Engineers Comments Regarding Surface Water Drainage

Application Reference:	BN/33/26/PL	Reviewer Reference:	ADC/EXT4b
Planning Officer:	Amber Willard	Date of Review:	01/05/2026
Site Name:	Land South of The Hollies 84 Barnham Road Eastergate PO22 0ES		
Application Description:	Construction of 2 No C2 (residential institution) dwellings and associated works (resubmission following BN/125/25/PL). This application may affect the setting of a listed building and is in CIL Zone 2 and is CIL Liable as new dwellings.		
Assessment Number:	1 of 2

Fig 4. Sewer Records

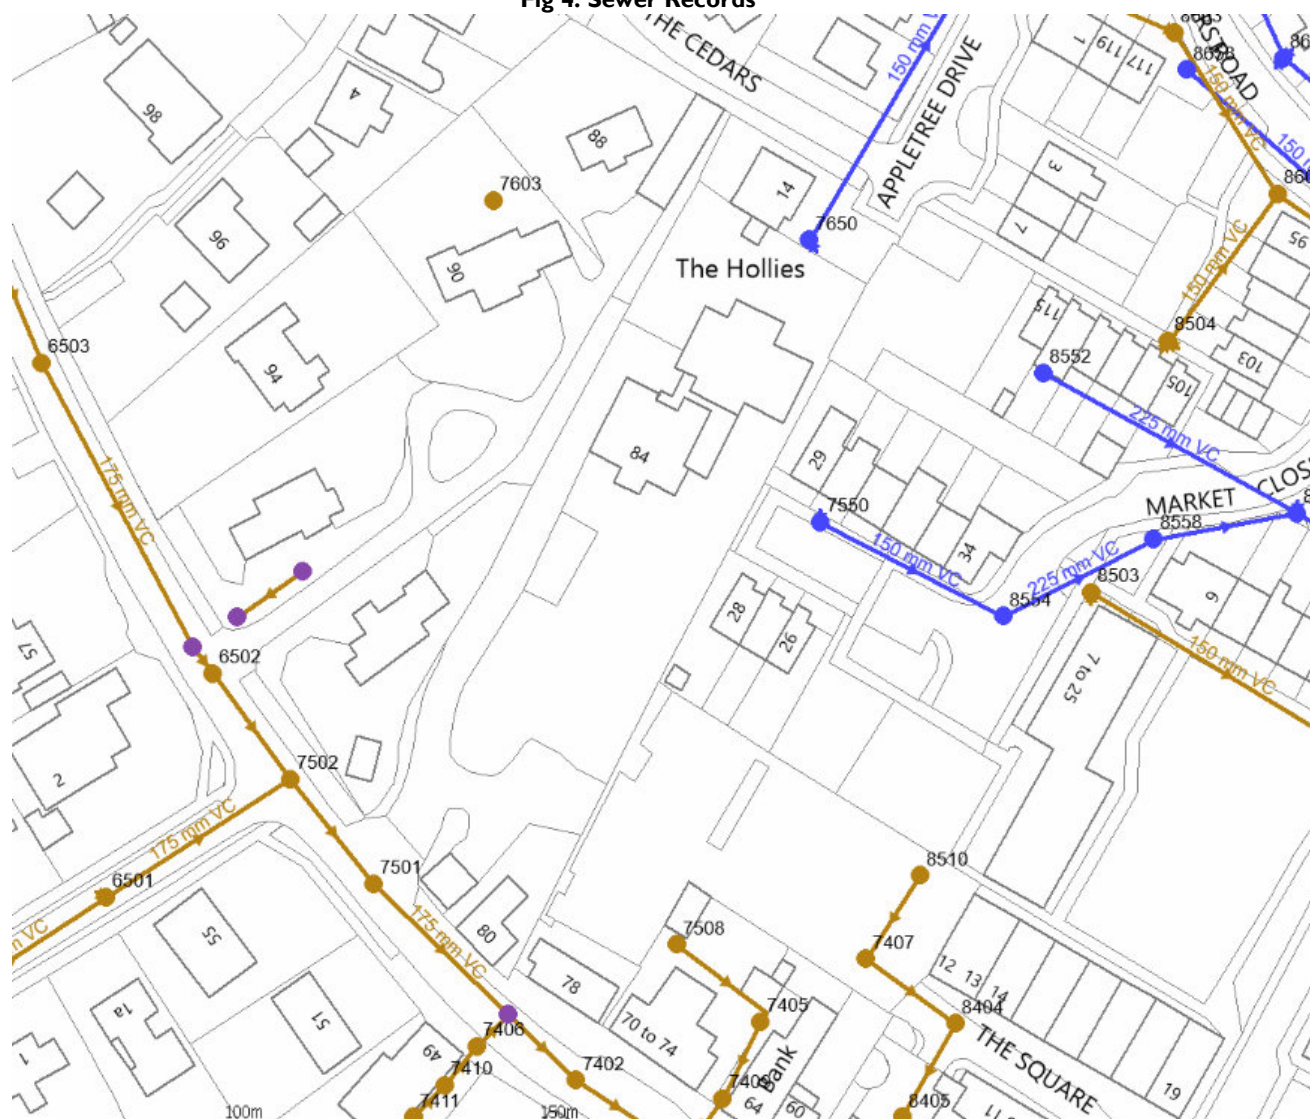
- 3.2. It is unclear if the outfall is likely to be surcharged as no information regarding its capacity has been submitted. If surcharging is likely, then this should be modelled to demonstrate that the system will still perform as designed under those conditions.

7.2 **Appendix B – Drainage Layout**

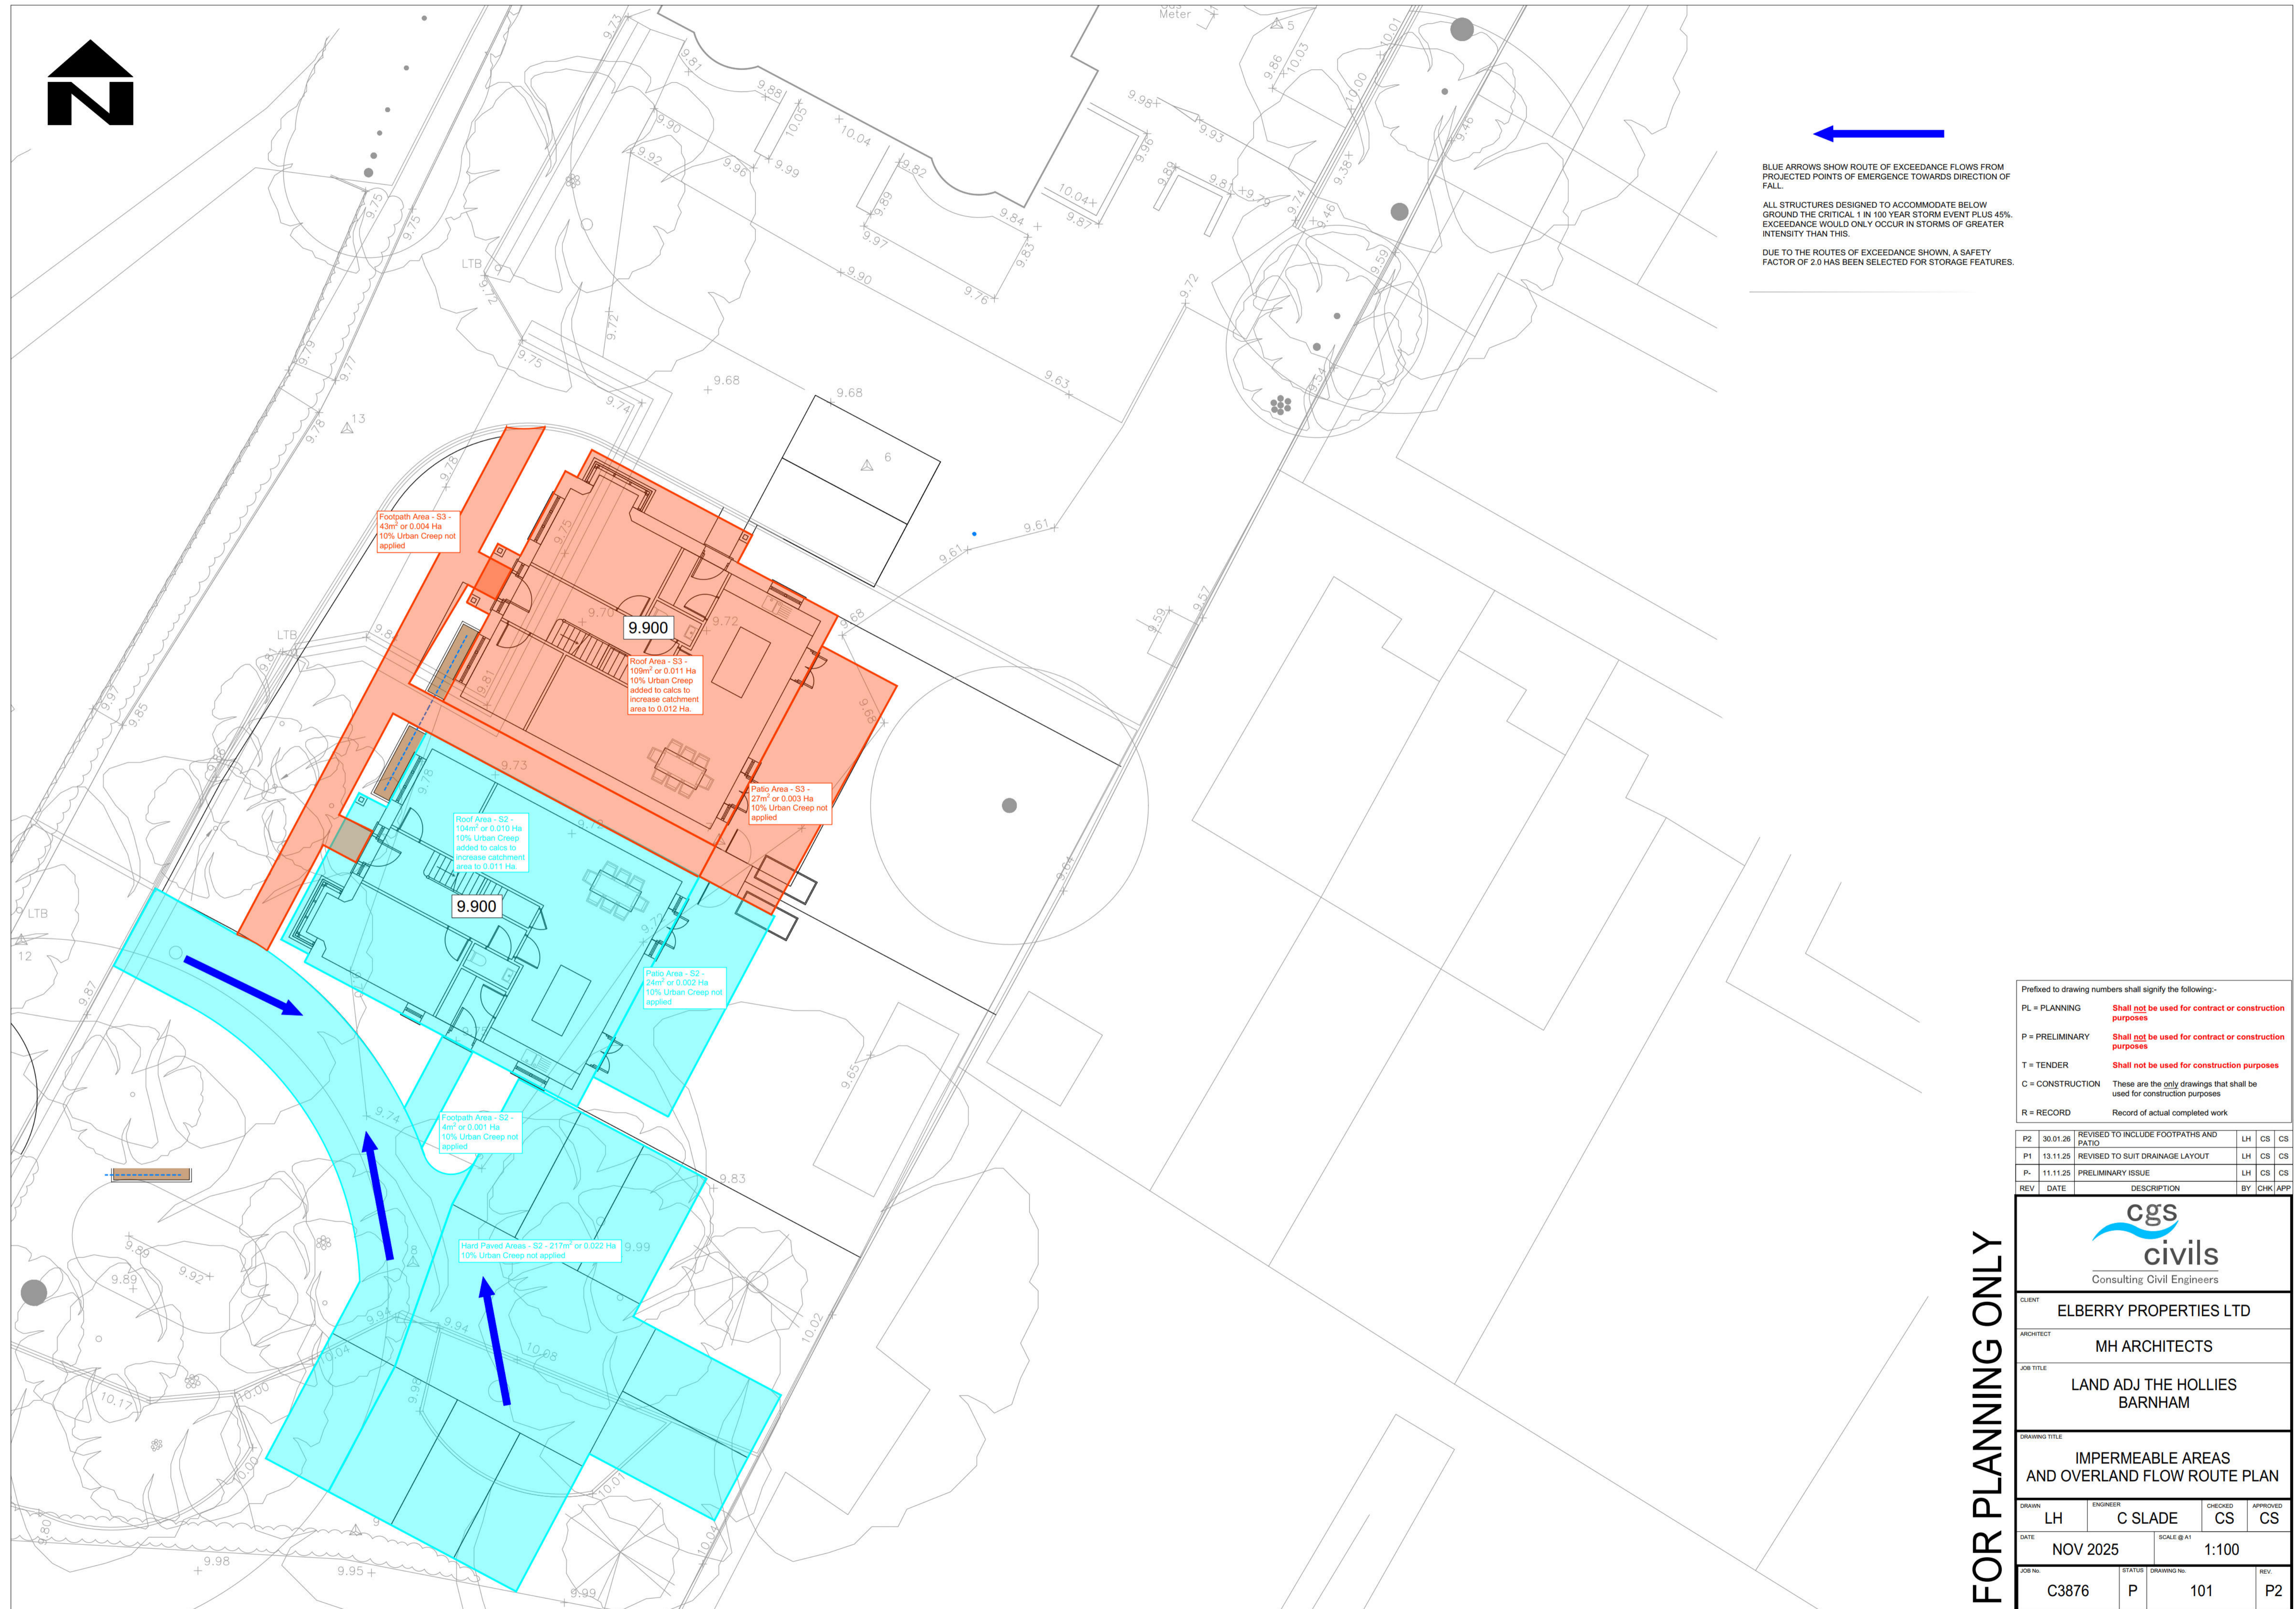
- 3.1. The proposed discharge rate of 0.5l/s is higher than the target 50% AEP greenfield runoff rate (0.1l/s) or 3l/s/ha (0.135l/s). However, reducing the discharge rate to either of these would increase risk of blockage and therefore increase risk of flooding onsite. To achieve the proposed discharge rate a vortex flow control is proposed, the diameter within this is 20mm. Where an orifice of less than 50mm is required to achieve the peak allowable discharge rate then the flow control should be robustly protected from blockage risk and the risk of blockage assessed and mitigated against. No evidence of this risk assessment has been submitted. Modifications to the design may be required to minimise the risk of flow control blockage.

- 3.3. Contributing areas do not appear to have been accurately modelled, rounding of the areas prior to their addition has resulted in the modelled area being approximately 10m² less than it should be. This is unlikely to affect the scale and layout of the development as additional capacity could be provided within the tank if necessary.

3.4. The connection to the existing surface water sewer relies on crossing third party land. As drawn, this is highways land (footpaths) and a greenspace owned by Arun District Council. Agreement in principle from the landowners has not been submitted. If consent is not granted it is unclear how the site will achieve a compliant surface water drainage design that does not increase flood risk as there are no obvious alternative disposal locations. **The planning officer should consider whether this should affect their decision**. In addition to the land ownership questions, as part of the detailed design process the design may need to be modified to ensure that the outfall pipe does not clash with the foul network in Market Close. The levels of the foul network are unknown and will need to be researched and clarified by the designer.

Appendix 1 - Tree Retention & Protection Plan

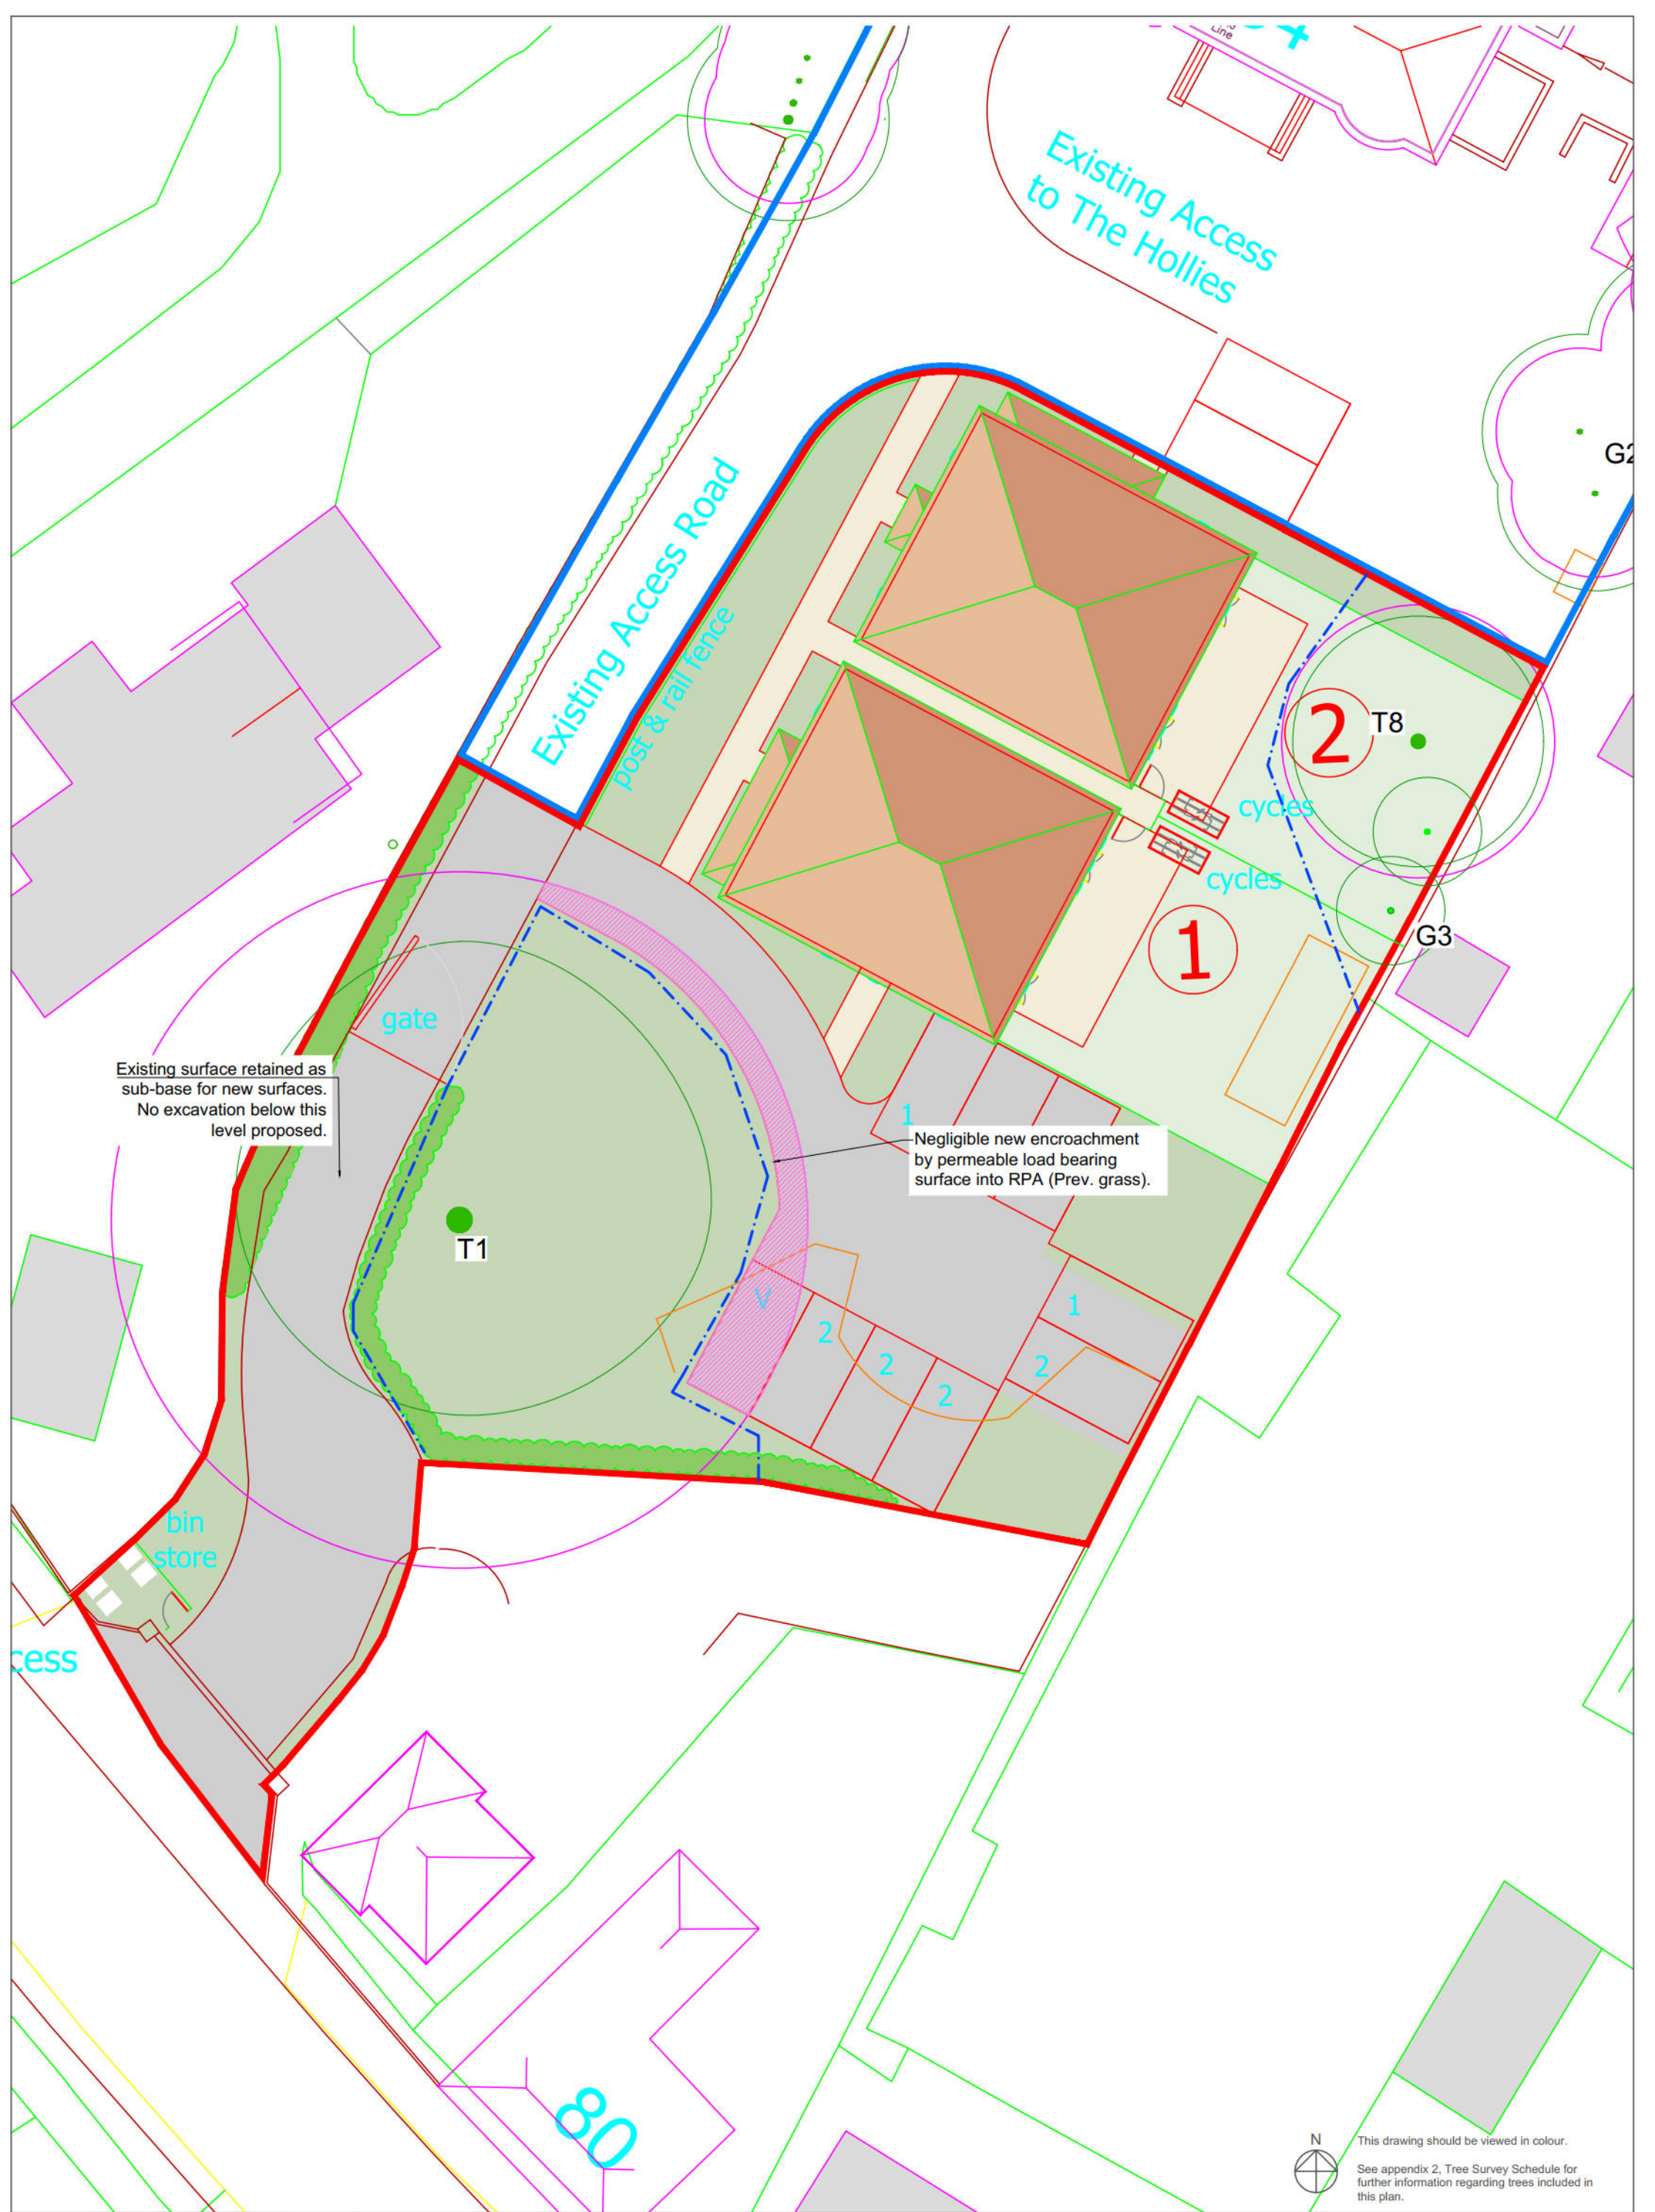
7.1. A tree which is the subject of a tree preservation order (TPO) is present in the southwest of the site. The access to the parking area skirts the root protection zone (RPZ) of this tree, with no-dig construction proposed. There are no pipes within the RPZ of this, or any other significant tree and the contributing area of the no-dig drive is accounted for in the design.

7.2. It appears (from satellite imagery rather than the plans) that the outfall pipe will cross through an area of existing trees. This is unlikely to affect the drainage design as the pipe may be protected without affecting the layout. **However, the tree officer may object to the installation of such drainage infrastructure if damage to the trees is likely to occur.** Please consult them in this regard.
